Online Comment

Application H08-0218-20
Location Site Adj. Silverdene Boston Road Gosberton PE11 4NR
Proposal Residential Development of 18 Dwellings - outline approval H08-0866-18

Name Angela Doherty
Address Housing Strategy

Date Submitted 17-06-20
For/Against Comments

Drawing Title:
Site Layout Plan
As Proposed
PLANNING APPLICATION ISSUE

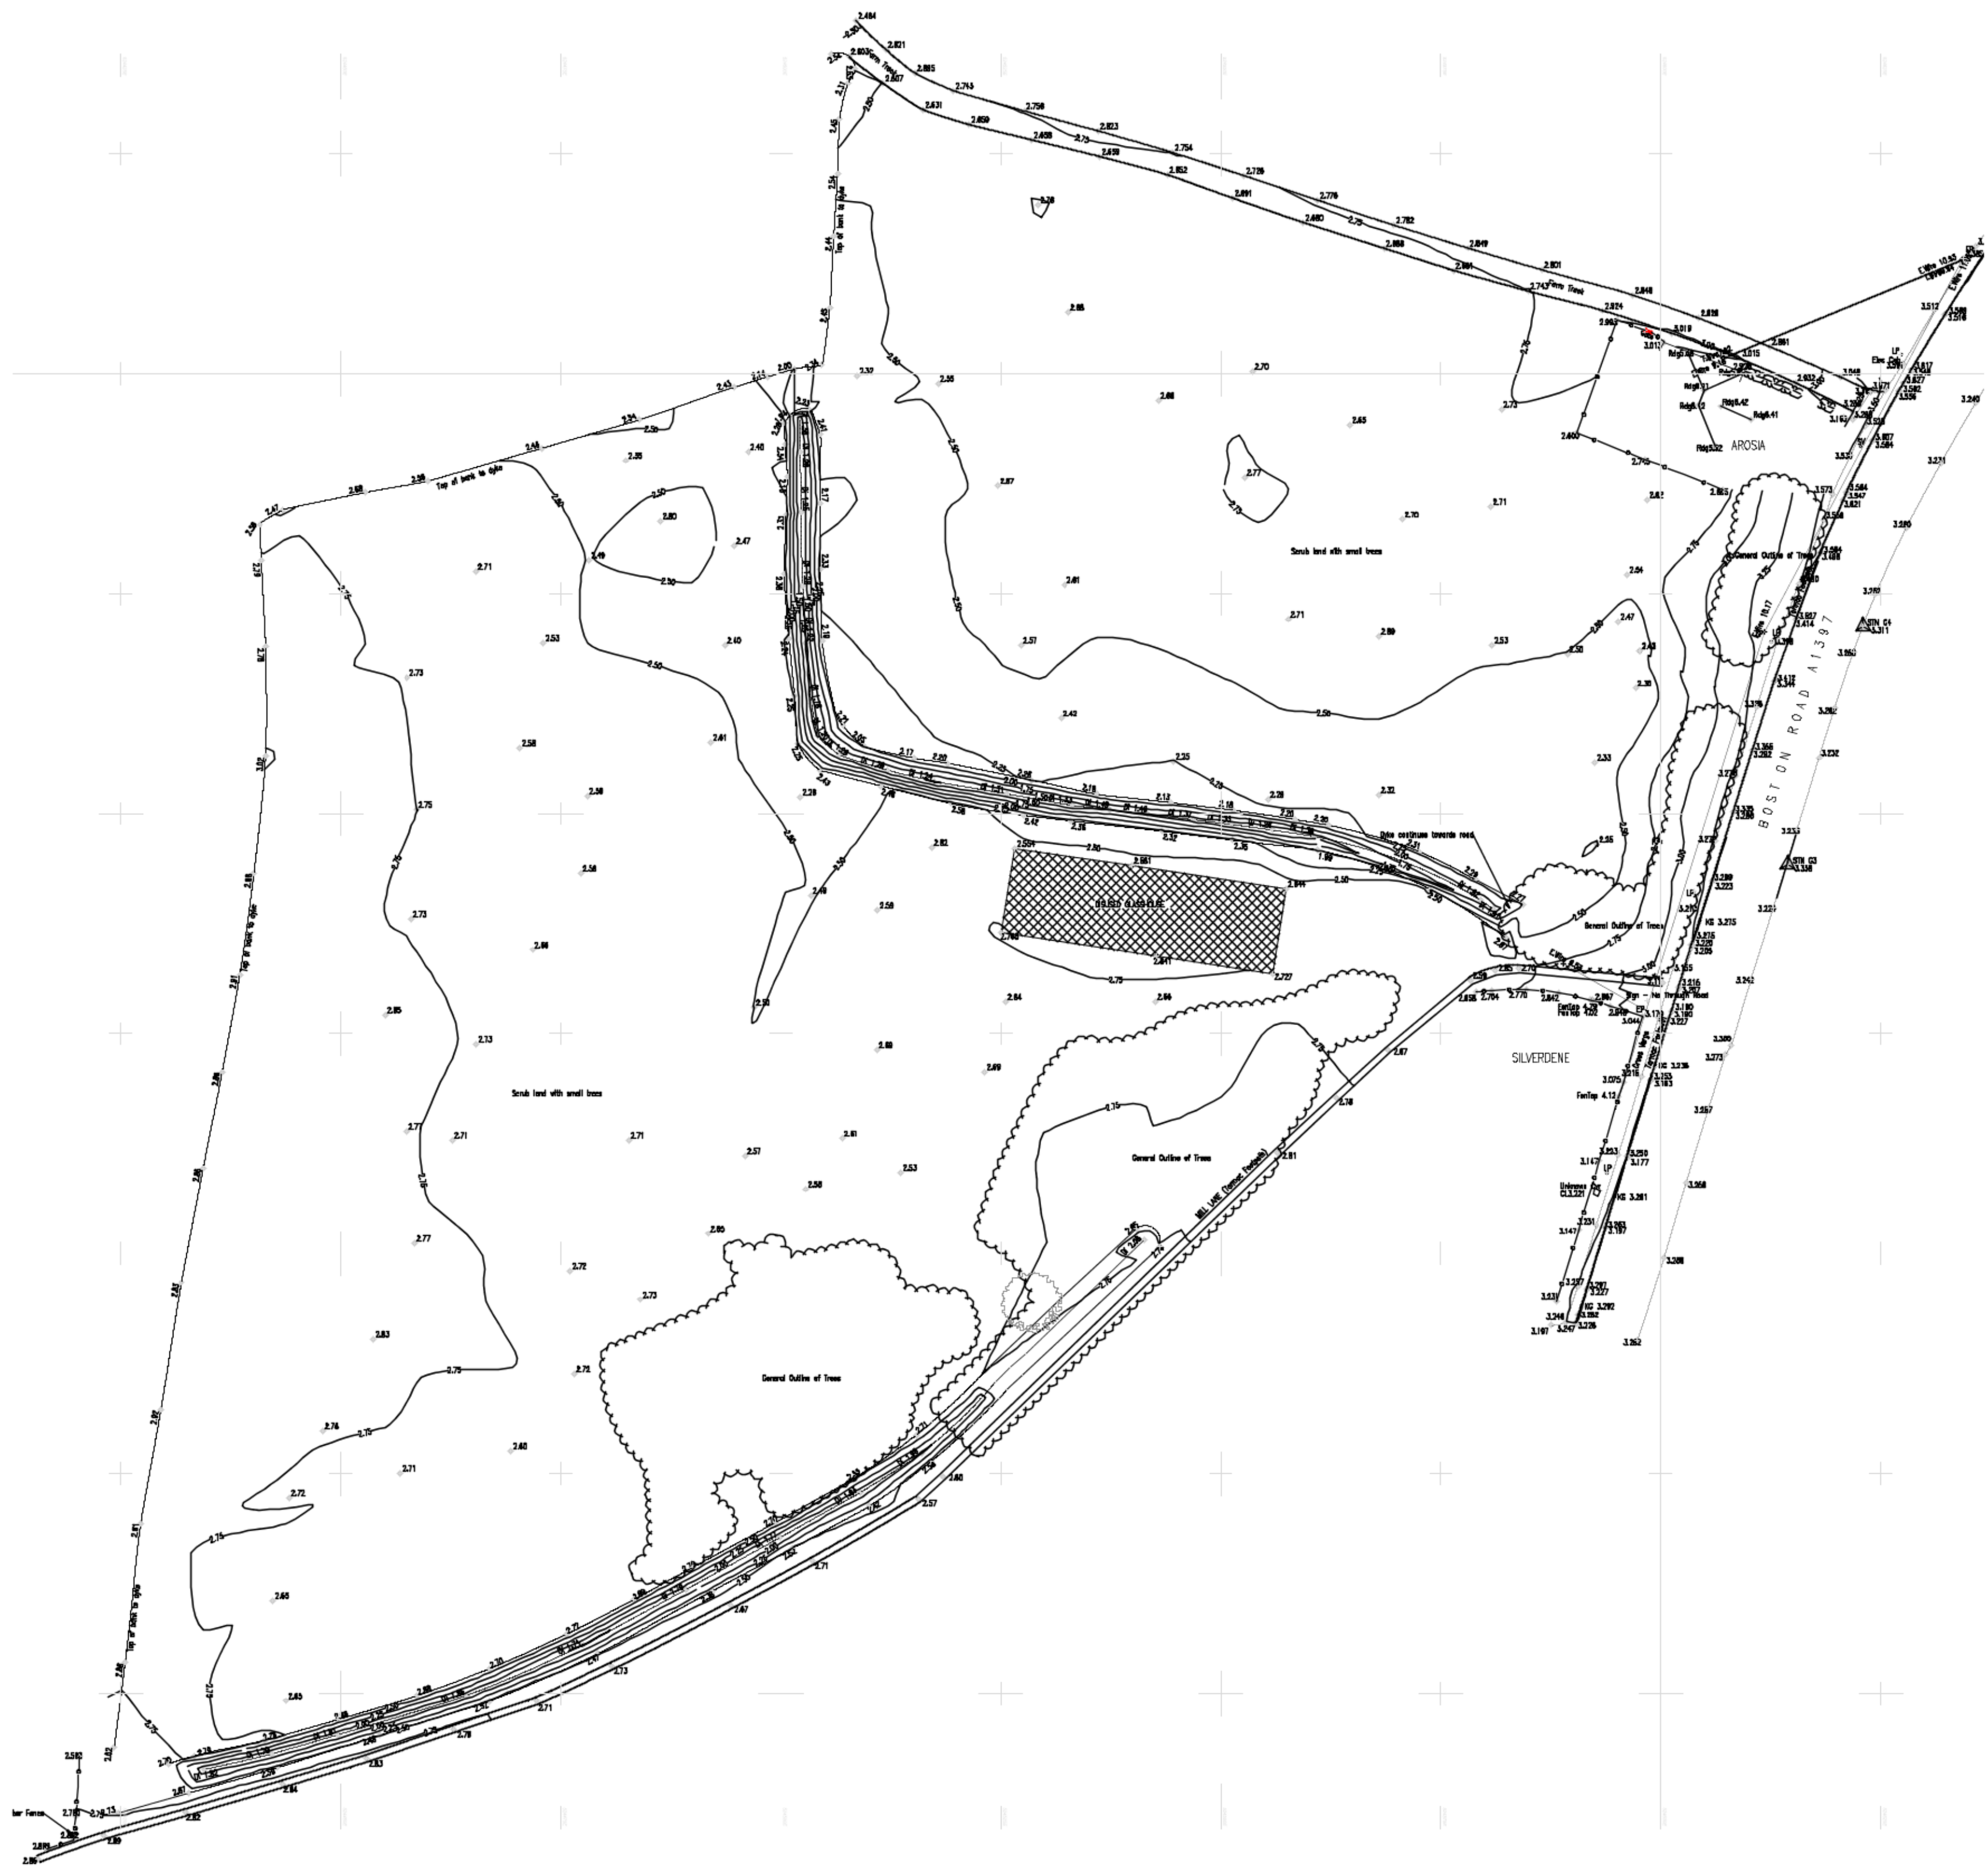
It is unclear the internal floor space of the affordable homes. As per the wording within the South East Lincolnshire Local Plan it would be preferable for the homes to be built to the 'Nationally Described Space Standards'. Ideally the affordable housing should be spread proportionately across the scheme to enable a mixed and sustainable community.
